**From:**  
**Sent:** 21 November 2025 18:50  
**To:** Louise Bearcroft; DC Admin  
**Subject:** Planning Application 2025/92737- Re Condition 17 Flood Exceedance Route

I am sending this email to you, to query how Condition 17, Flood Exceedance Route, relating to Planning Application 2025/92737 can be classed as met and discharged, as stated in Martin Stephenson's, KC, Lead Local Flood Authority, Consultation response dated the 5th November 2025. This consultation response was based on details in the document supplied by Align Property Partners PV2511-APP-92-XX-DR-C-2501 dated 26.09.2025.

This document supplied by Align Property Partners has now been moved into superseded documents [id 1107228] 30.09.2025. Align Property Partners have submitted an updated Flood Exceedance Plan [id1113906] 13.11.2025.

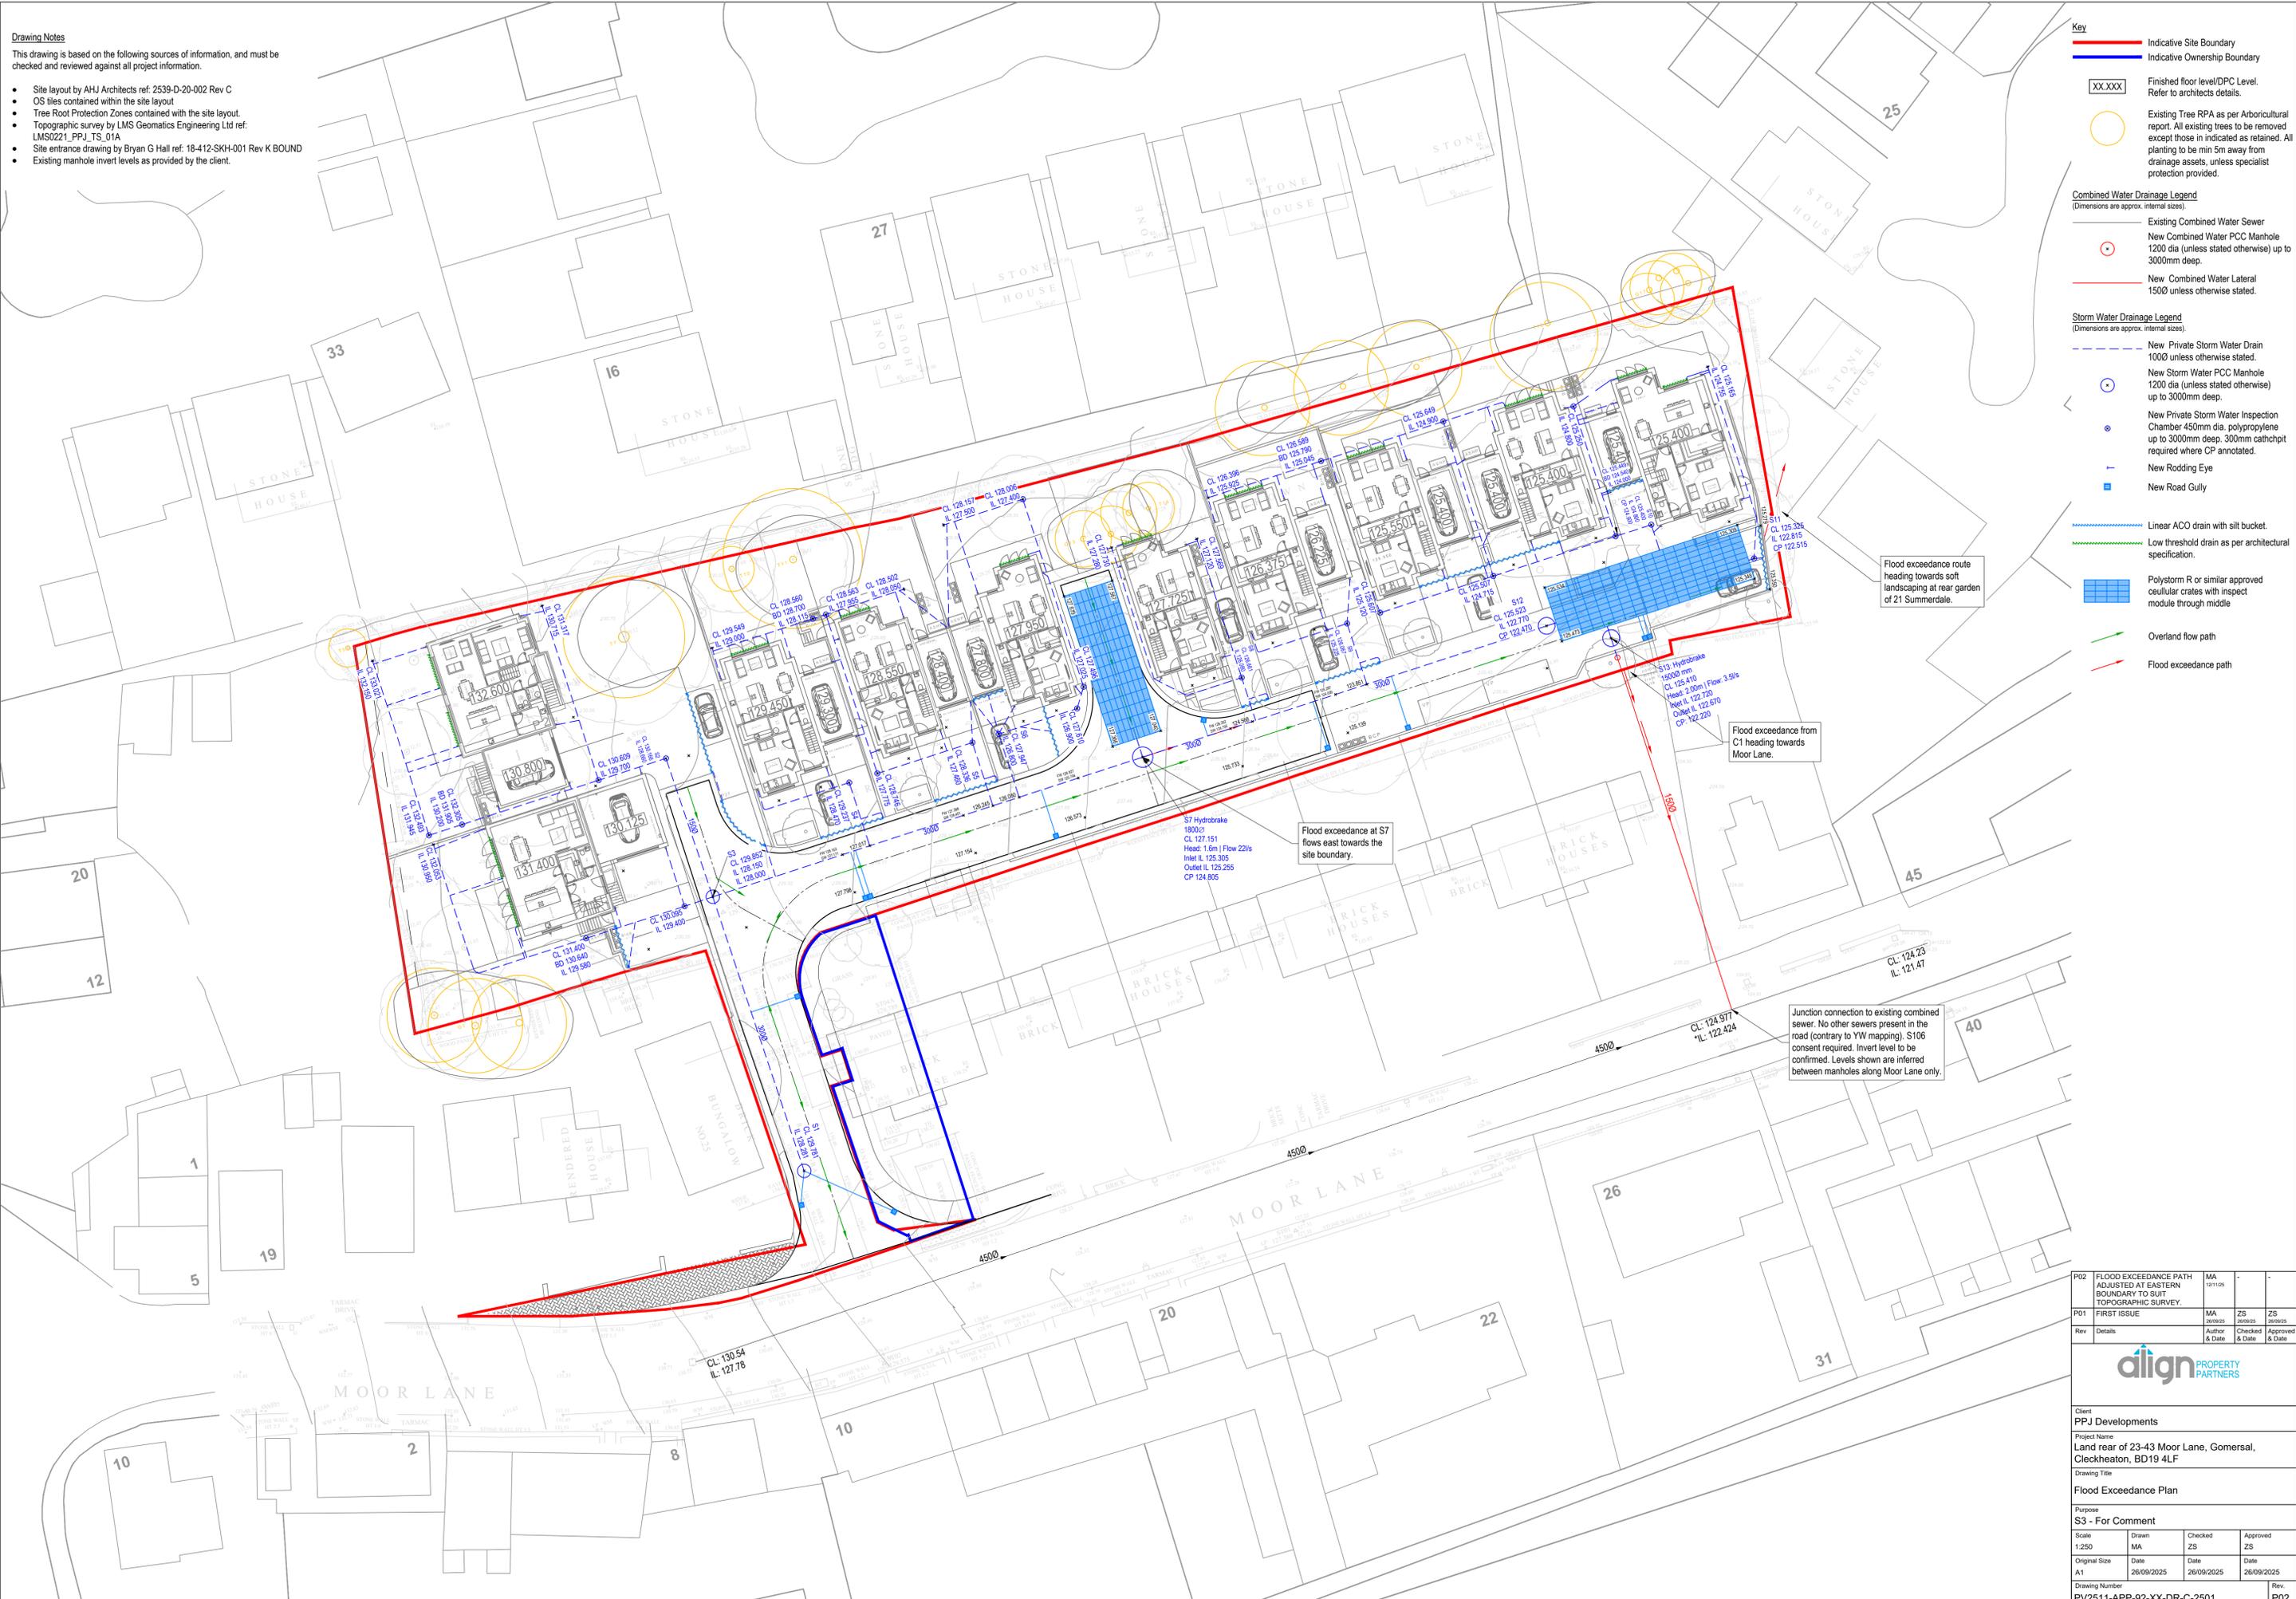
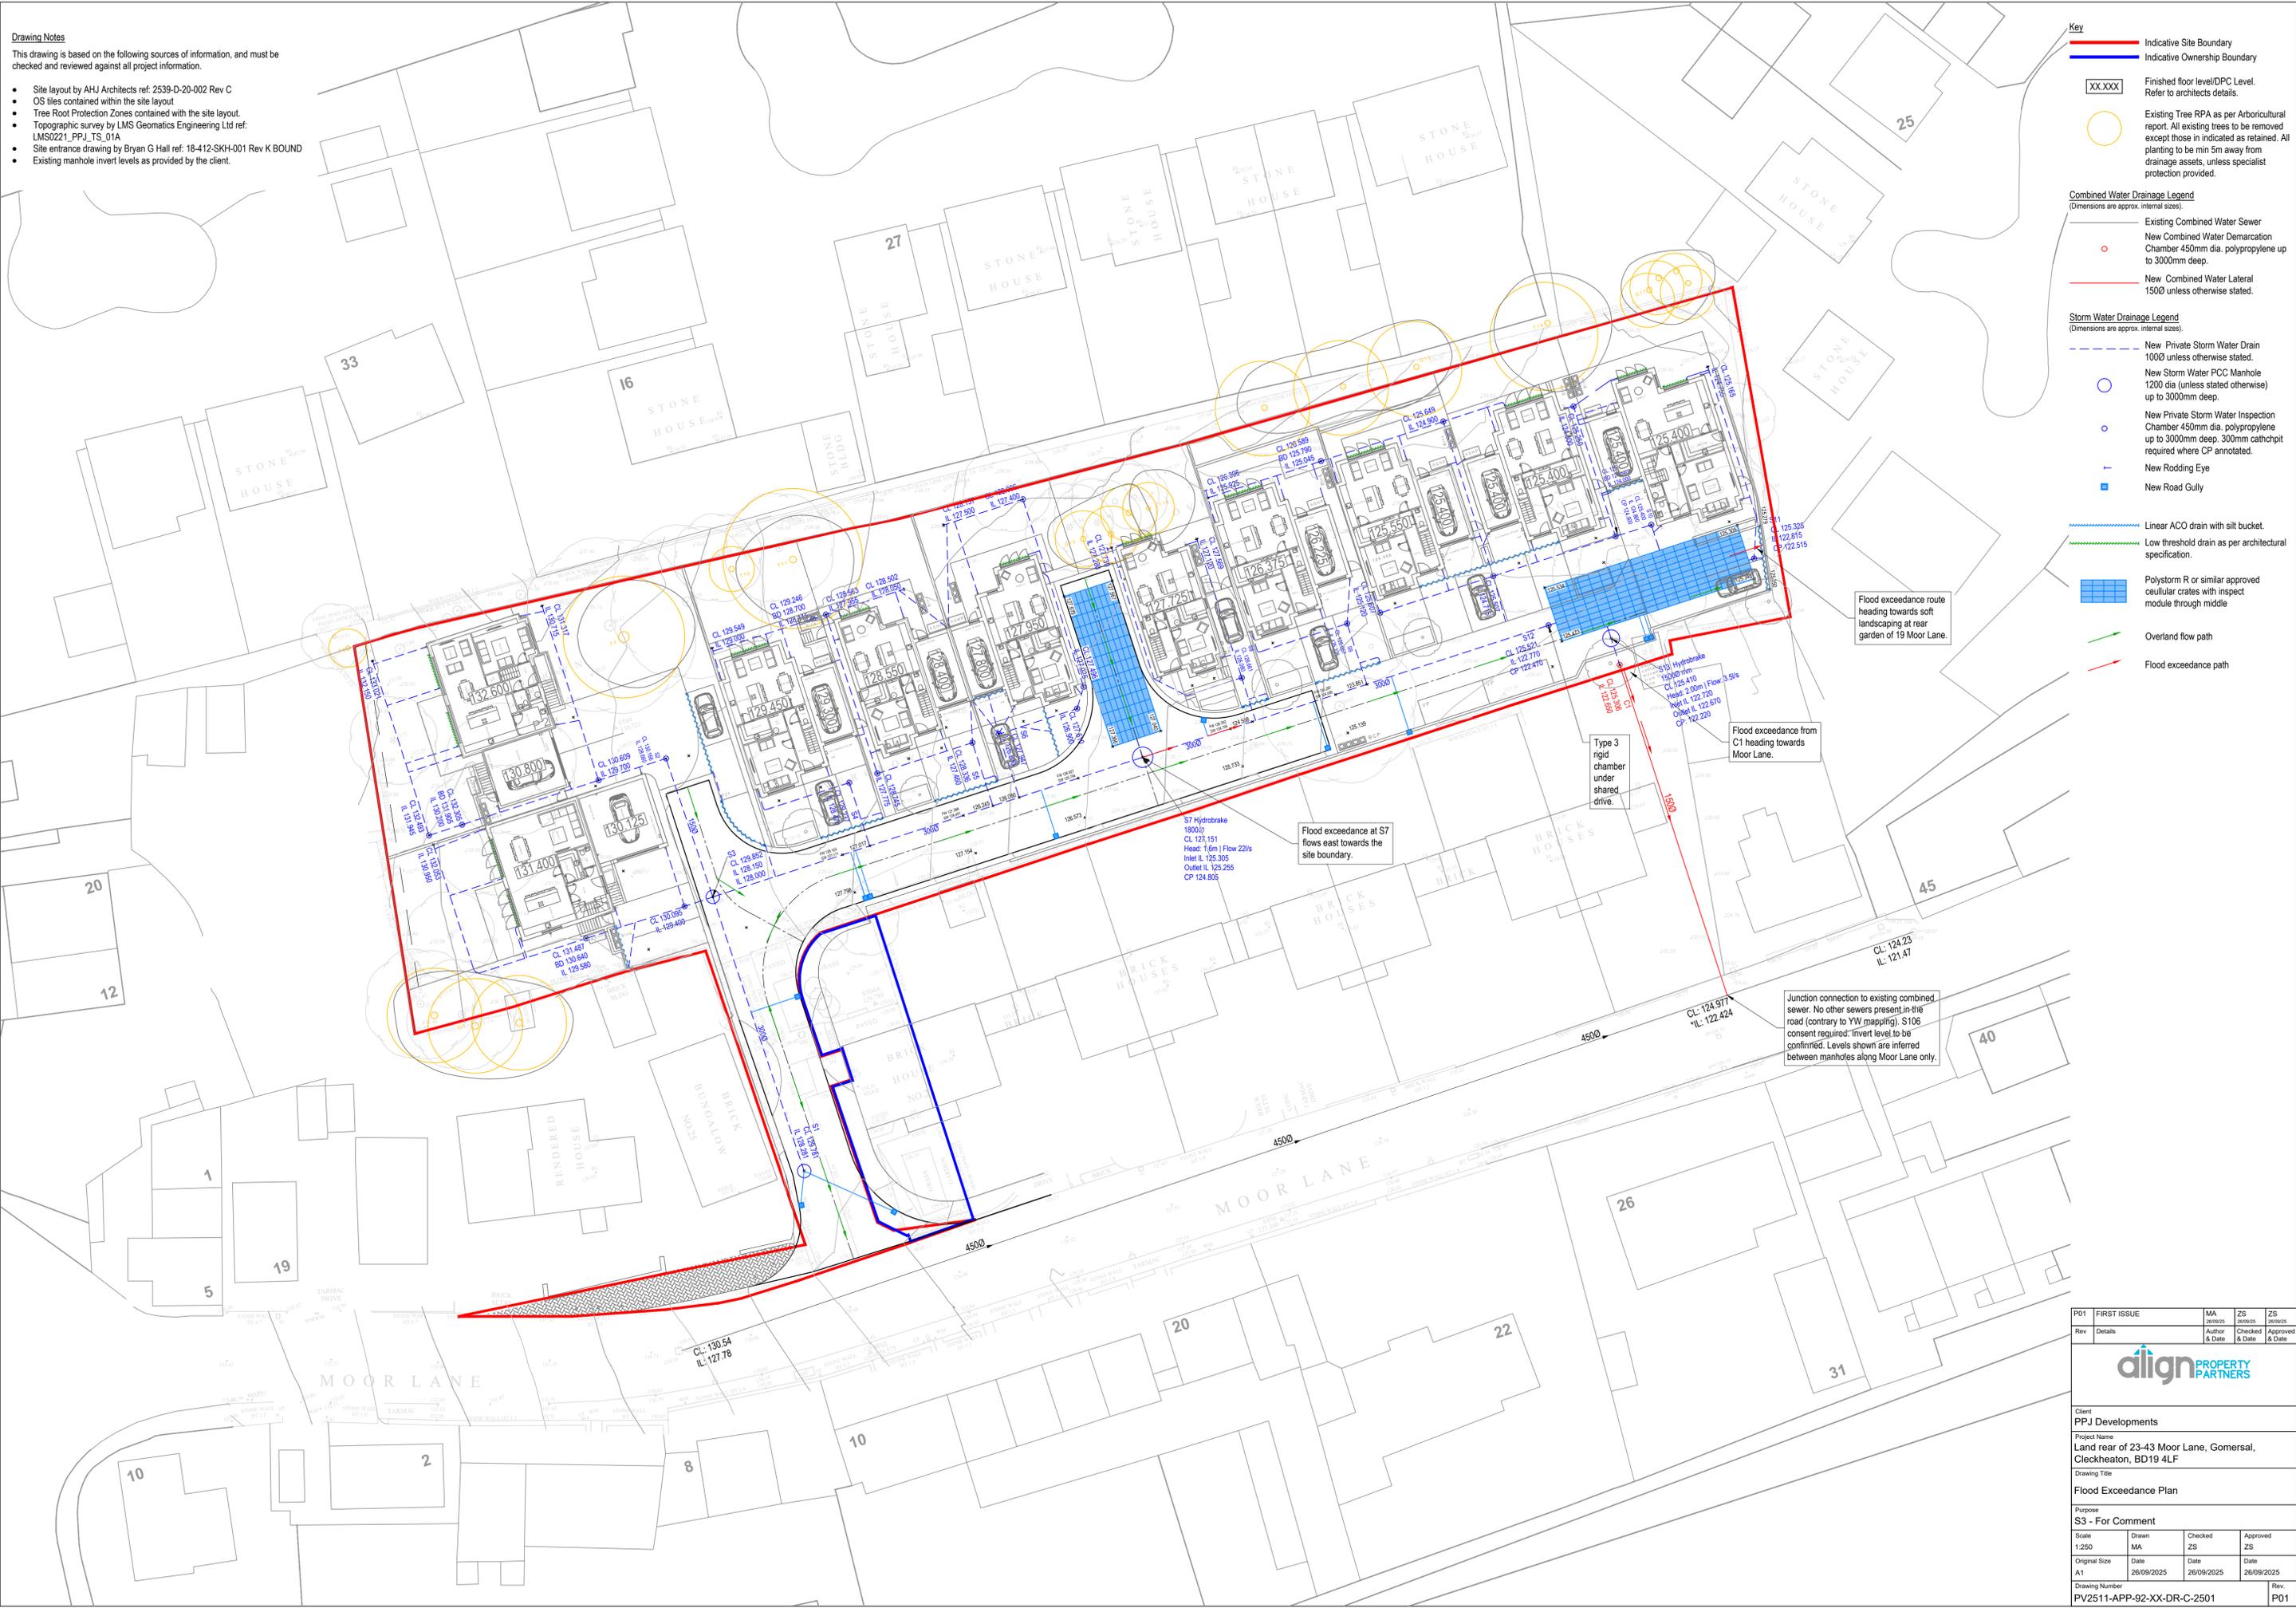
As this new plan is specifying my address as the route of this flood exceedance, I have submitted a formal objection to the new flood exceedance plan, emailed to Louise Bearcroft and dc.admin@kirklees.gov.uk, on 19th November 2025.

I believe this flood exceedance route to be unlawful, as nobody should increase the flood risk to another persons property. Also nobody has requested my permission for this flood exceedance route and I am formally registering with you, Kirklees Council, that I do not give my permission for this flood exceedance route to be re-directed towards my property or any flood excess to enter my property.
